**From:** Matt Augustine <matt.augustine@gmail.com>  
**Sent:** Monday, March 30, 2020 9:53 PM  
**To:** Nicole Gaudette  
**Subject:** Comments on 74XX SE 38th Street Proposal (CAO19-015)

CLEARING & TESC

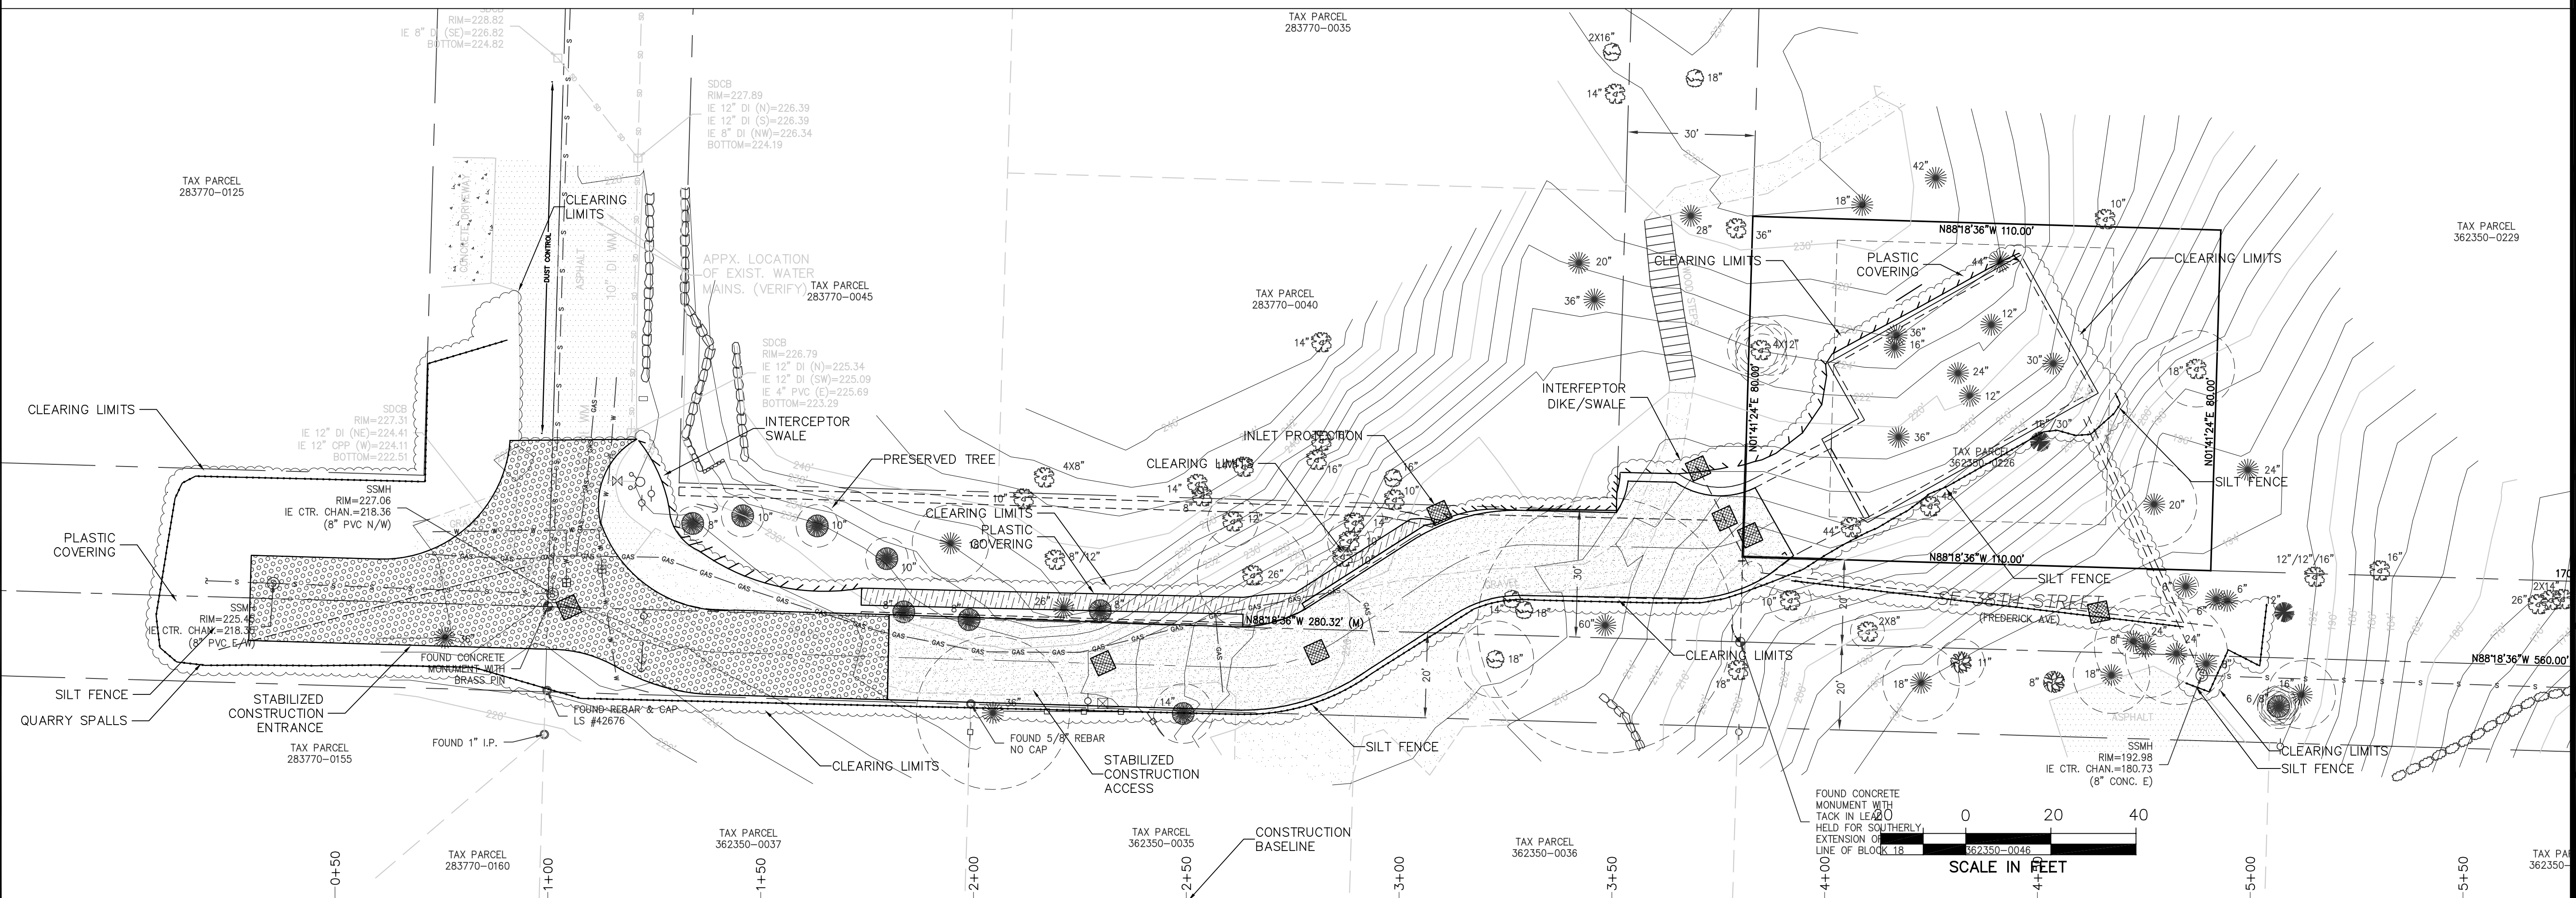
3. There is a large Douglas Fir tree very close to the project site - I believe just east of it - which houses a Bald Eagle nest. The nest has been active for many years, and everyone in our neighborhood loves listening to the eagles and watching them come and go.  
I didn't see any mention of this nest in the project documents. Would the proper steps be taken to avoid disturbing the eagles during site preparation and construction?

PAVING AND GRADING PLAN & PROFILE

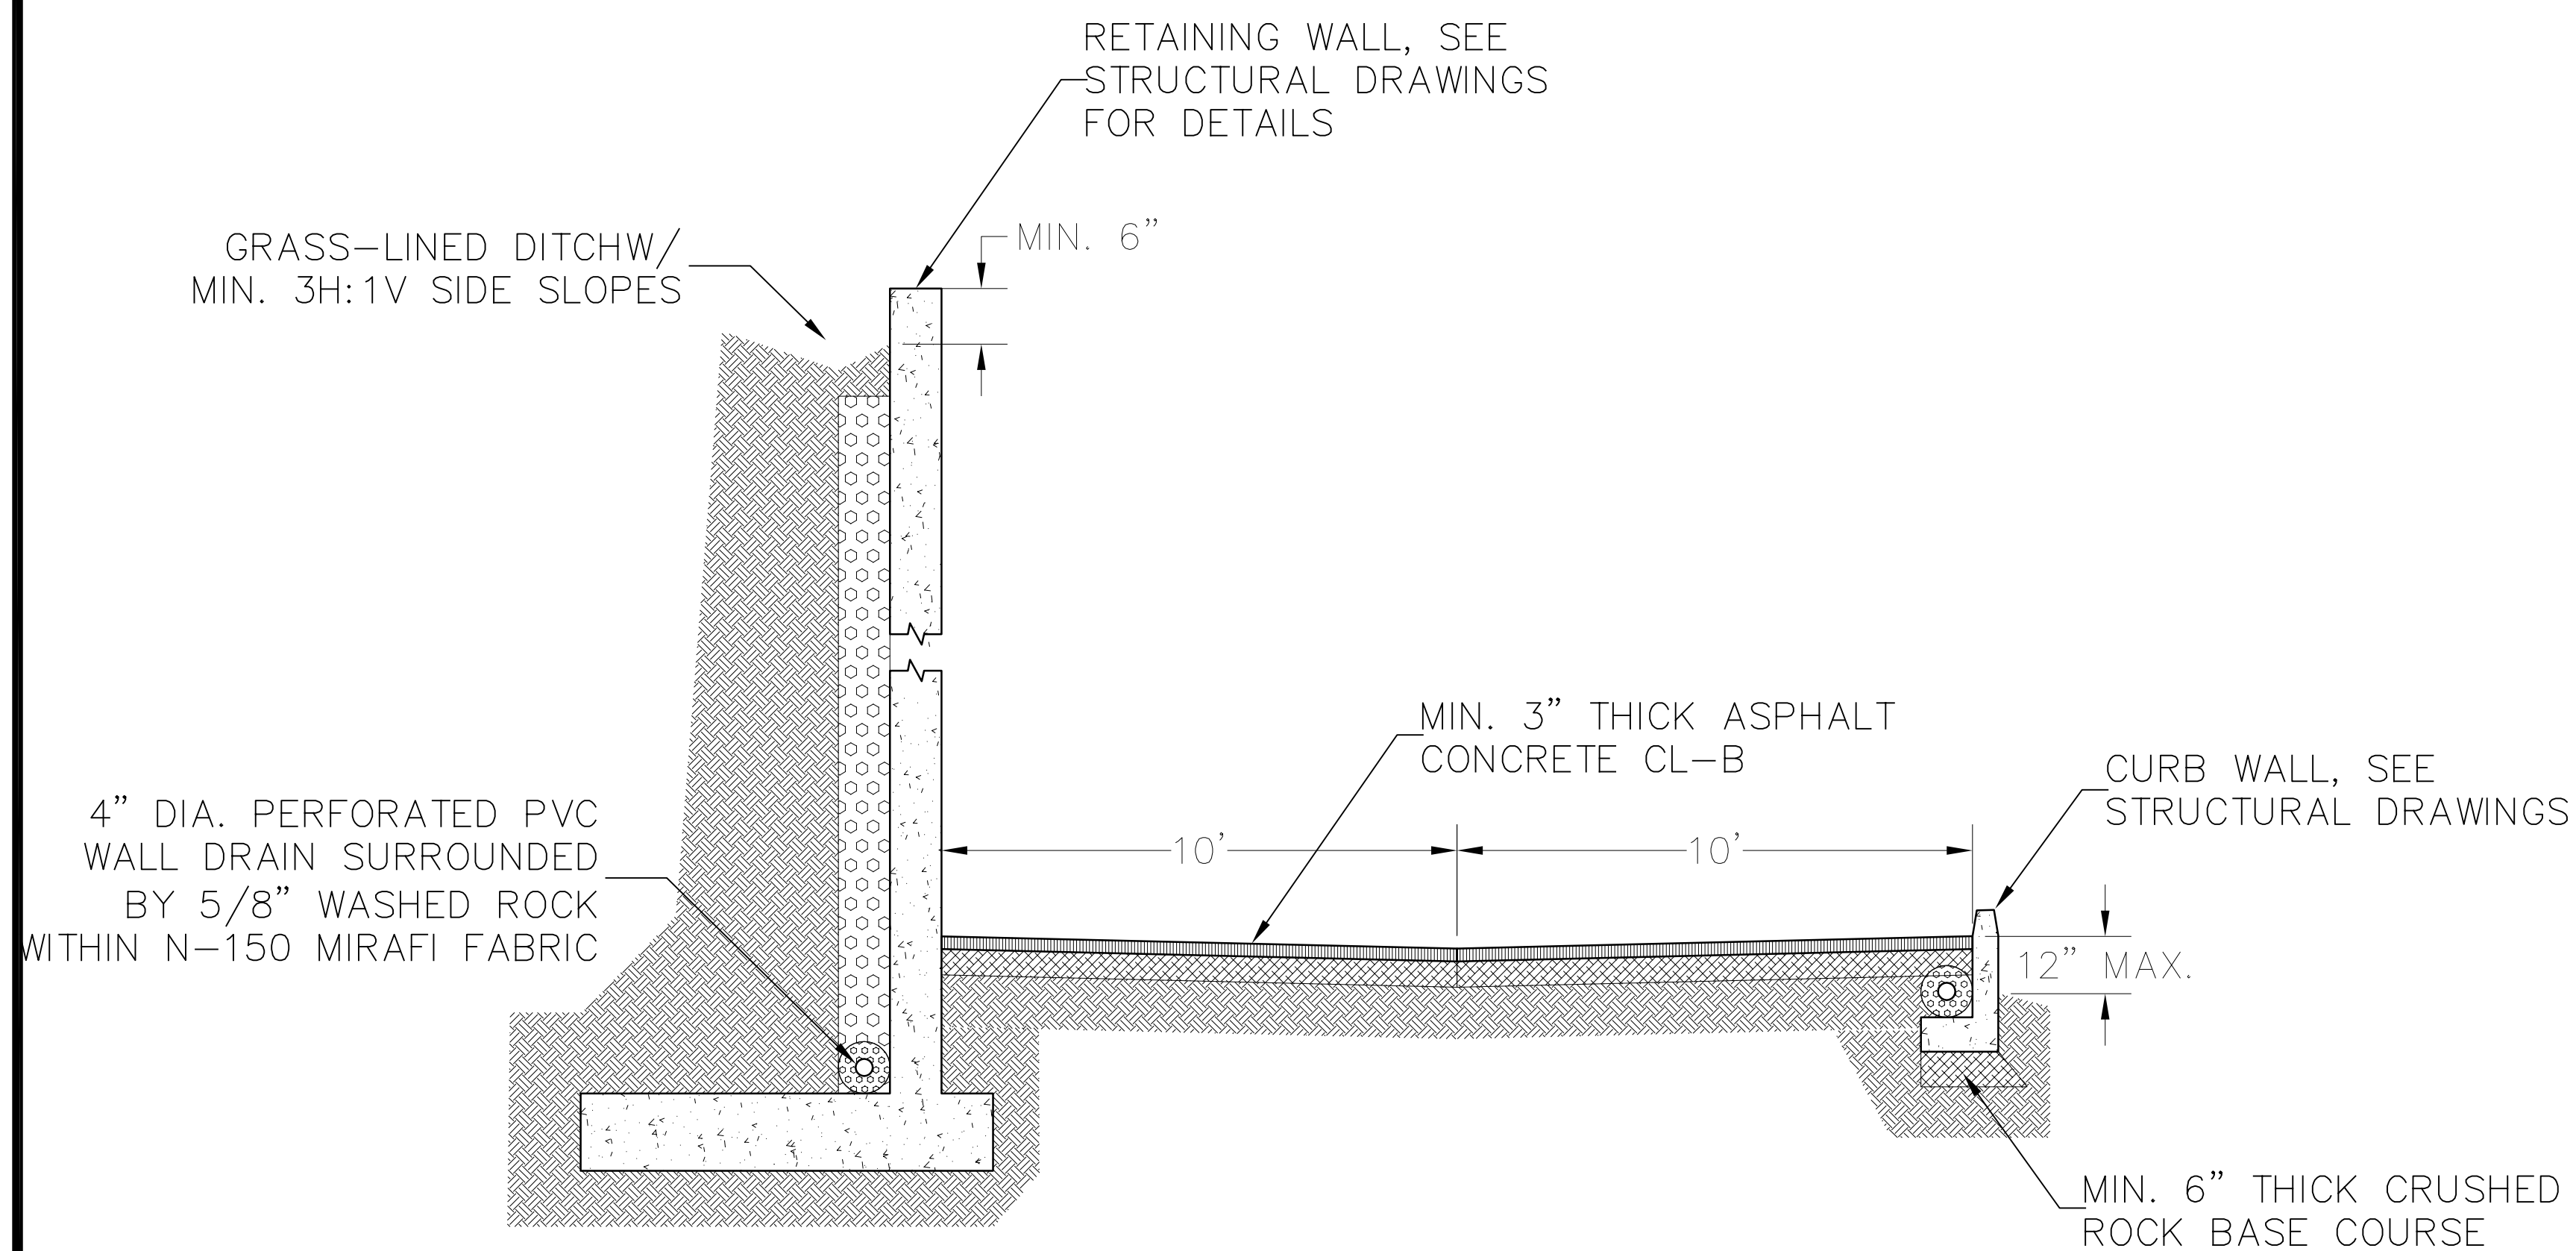
1. The project site, along with a portion of the paved access drive in the right of way, is up a steep slope above our property. The area at the base of that slope in our backyard already stays pretty wet and muddy after a rain, and the ground is quite soft. I worry how the increased runoff from the impervious area introduced by the development would affect the drainage on my property and the stability of the steep slope above it. In the engineering plans, I see mention that this water will be "discharged at the bottom of the slope south of the project parcel." Does that mean that it will be directed onto my property?

2. My family and I are avid users of the trails in Mercerdale Hillside Park, and we love being able to walk right up to the trail from our backyard by taking a short path across the right of way. Many of our neighbors cut through our driveway to do the same thing every day. I hope that our convenient access to the trail would not be impeded by the access drive proposed in the right of way.
